10 December 2019

Re: New Catherine Field Primary School, O'Keefe Drive, Oran Park (SSD-9477)

Our primary concerns are as follows:

1. Height and Location of Buildings.
2. Verge Widths and Landscaping Along the Southern Boundary

Landscape plans for southern perimeter road

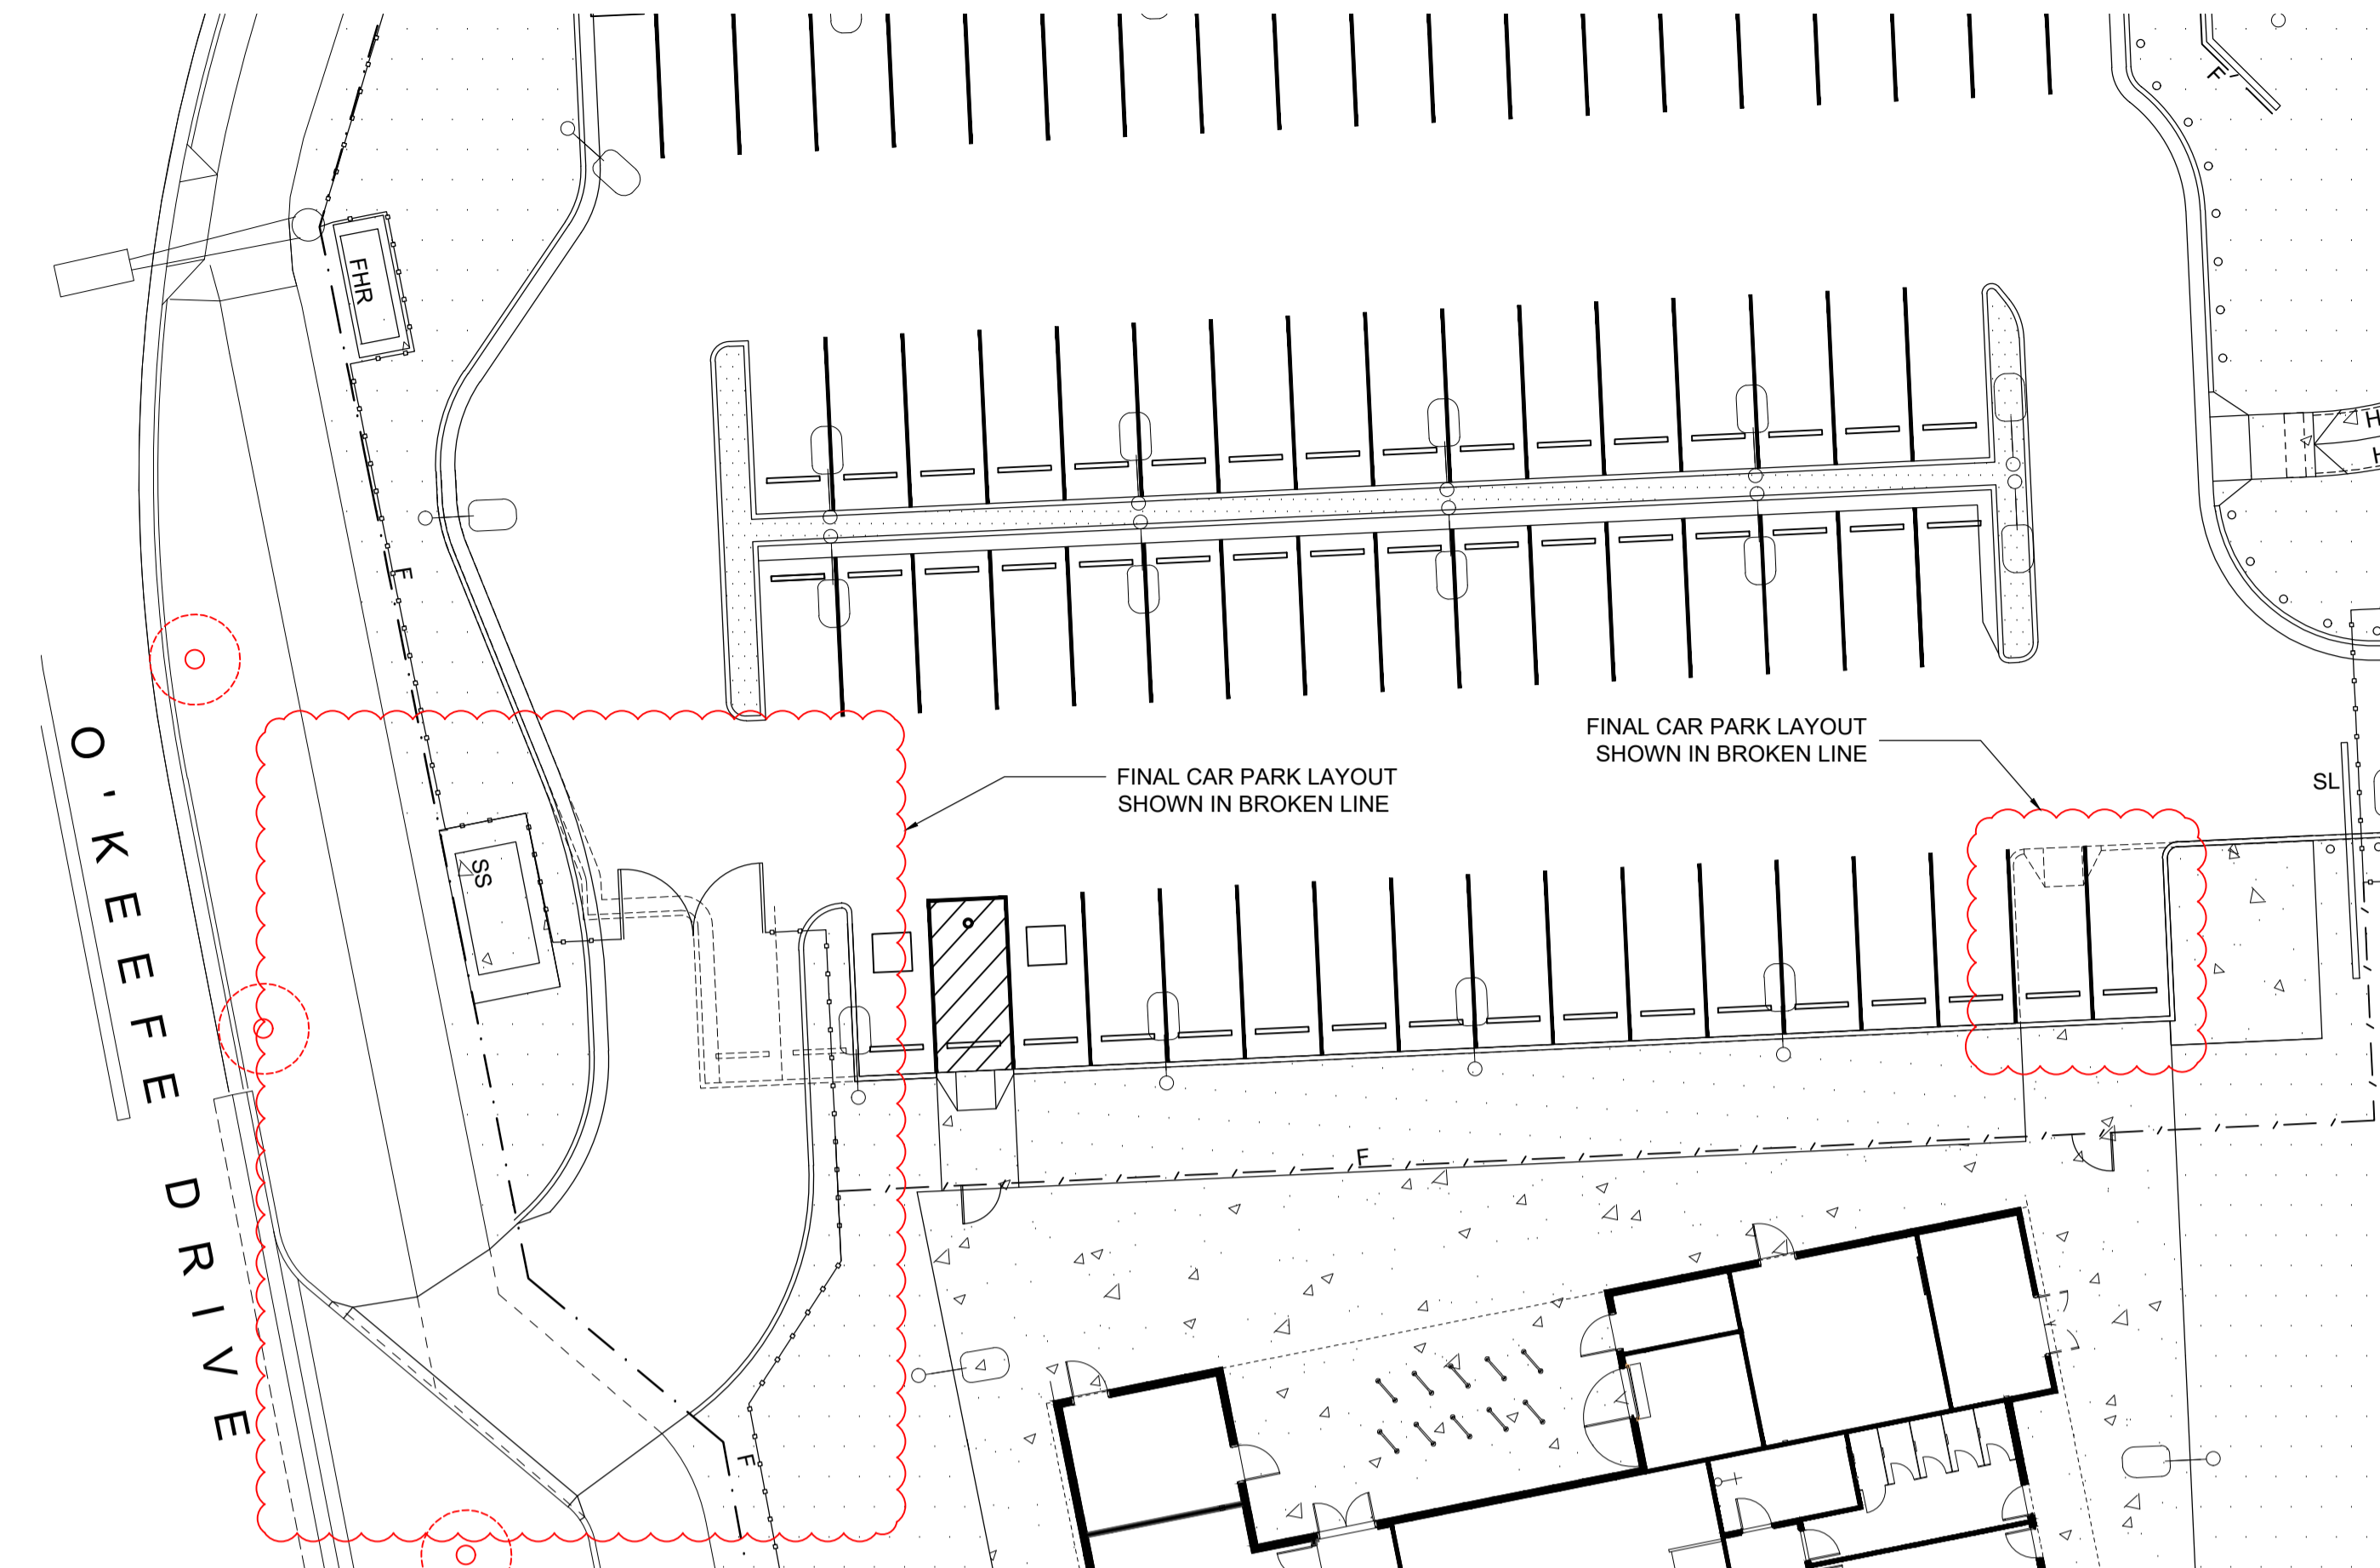
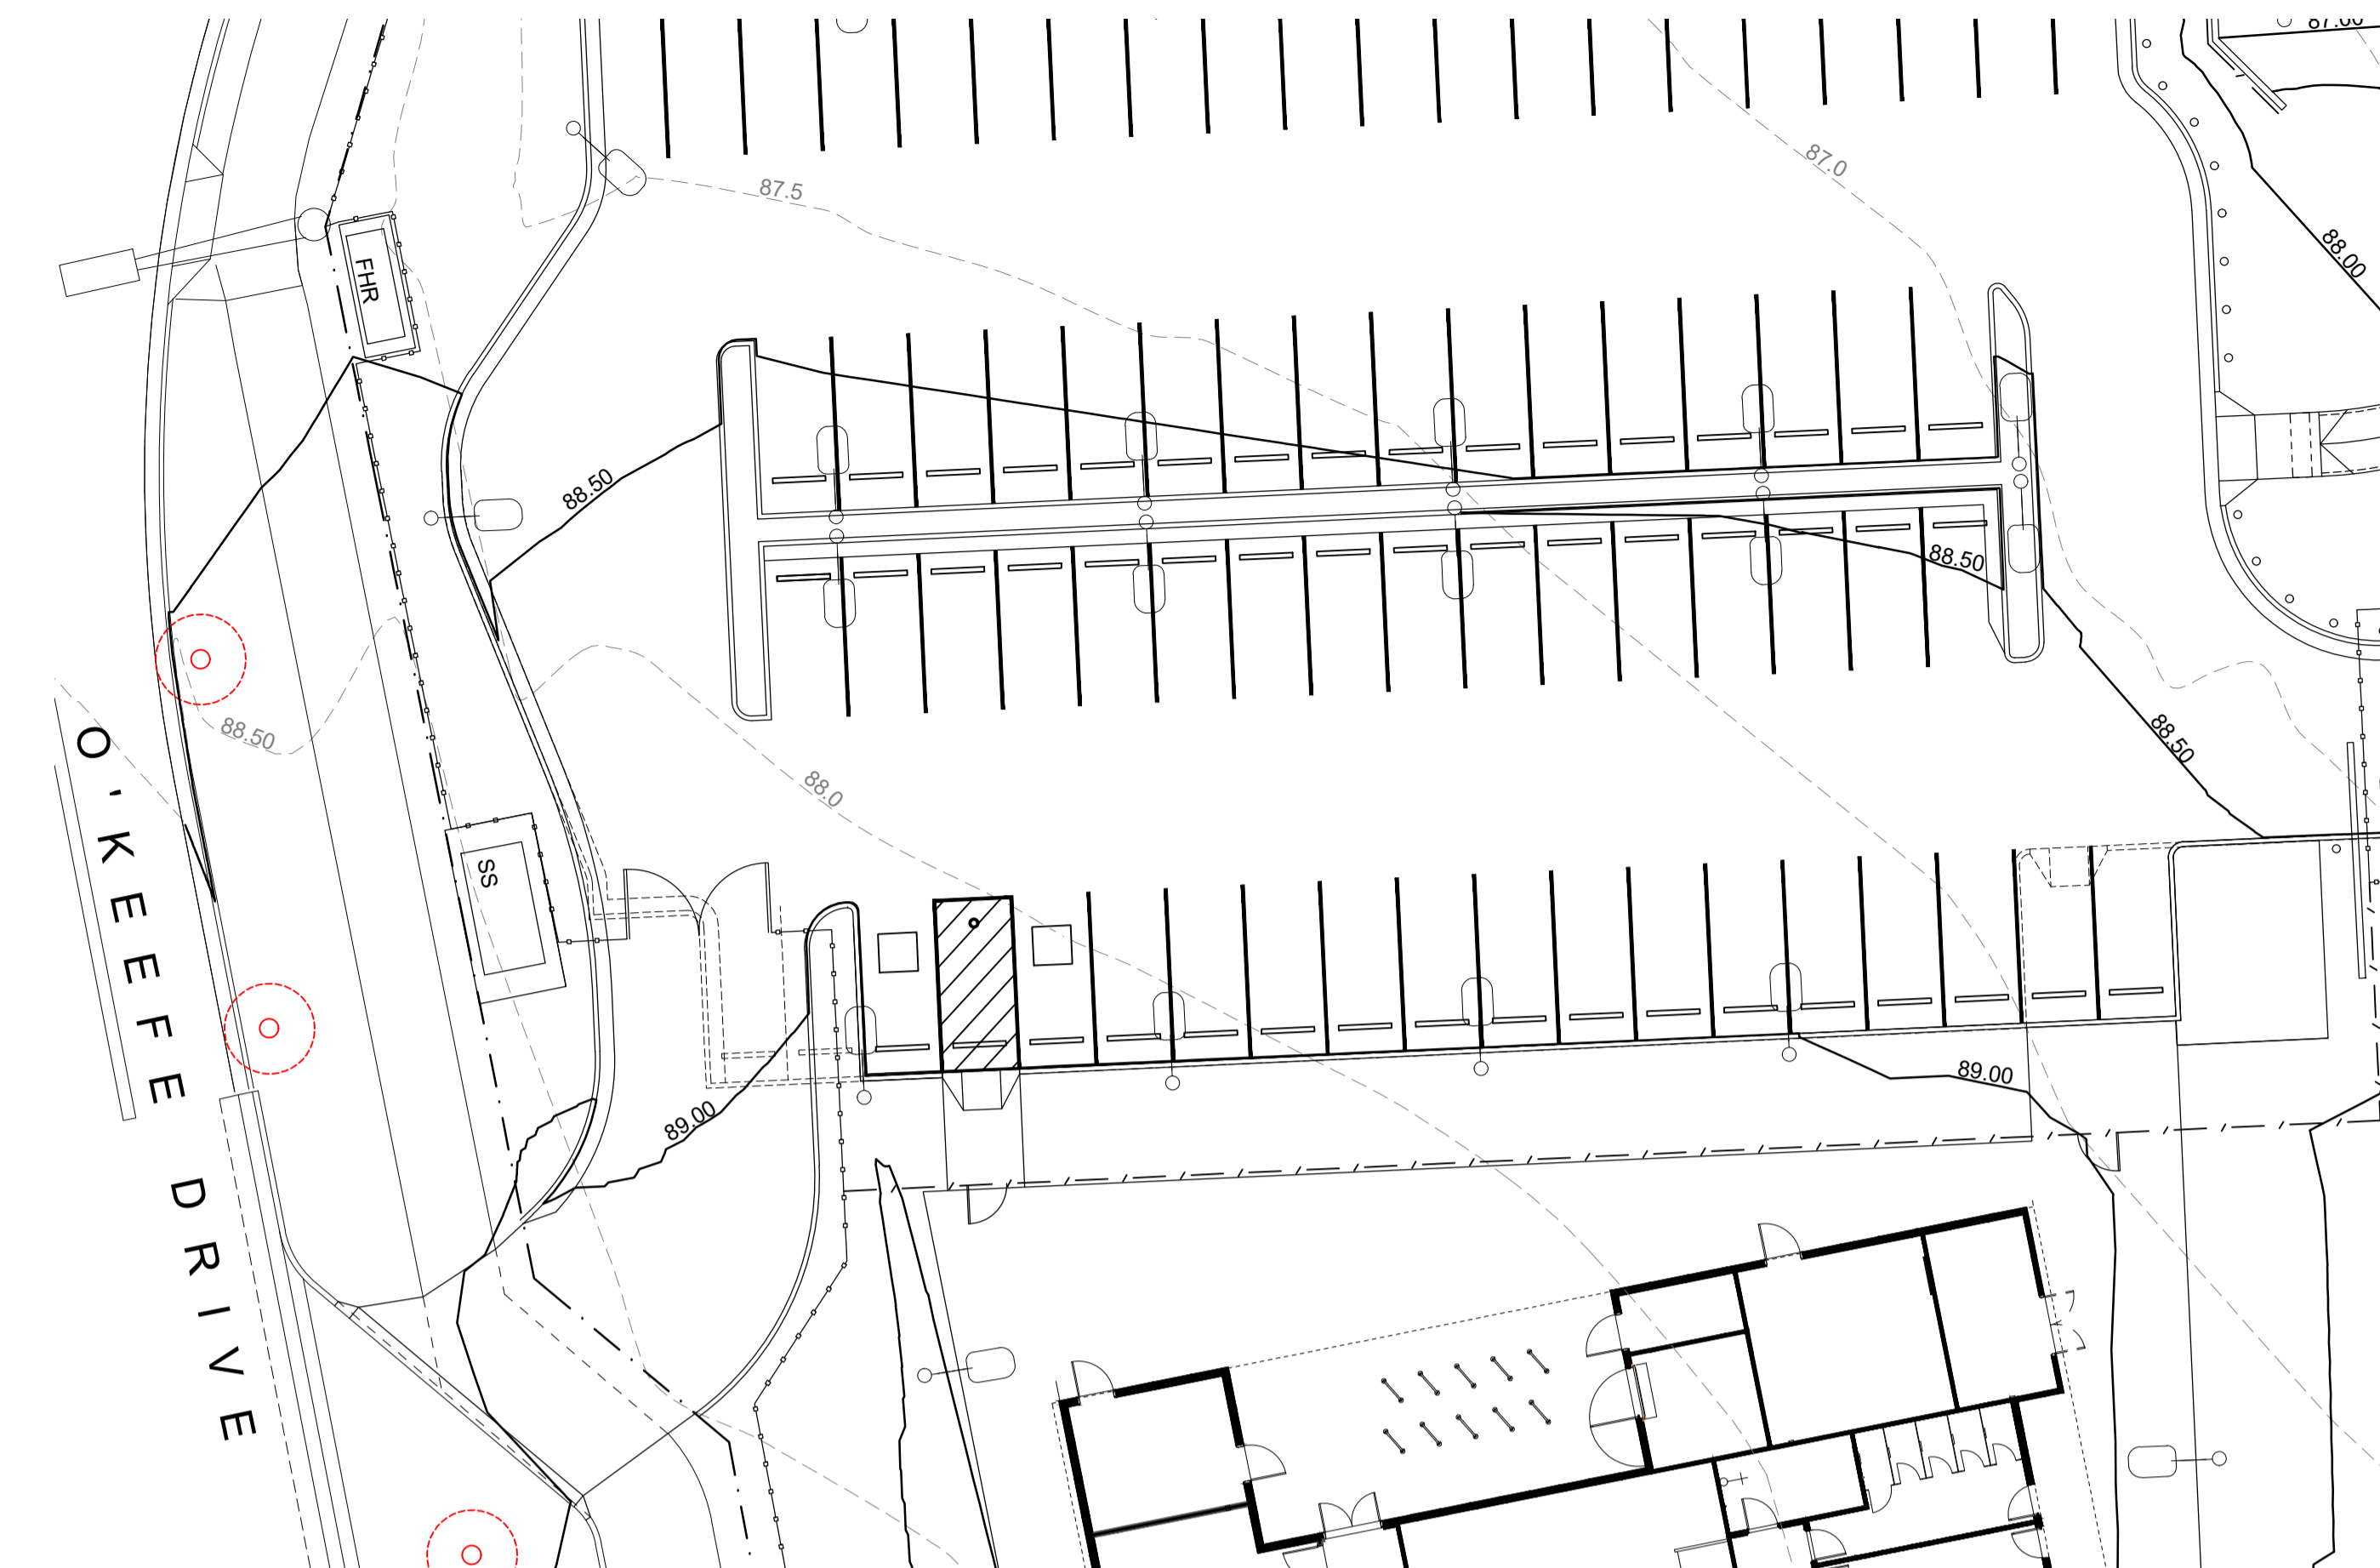
We also have concerns about the street and landscaping design along our common road. These issues have been raised previously. We understood that we had agreed certain outcomes with the Department but these have not been reflected in the design. These outcomes included:

- Widening the verge to accommodate a proposed cycleway
- Construction of the diplomat fencing behind the property line
- Articulation of the fence line and inclusion of architectural features
- Placement of a hedge and landscaping in front of the diplomat fencing
- Street landscaping and tree planting to a high standard in keeping with the surrounding areas.
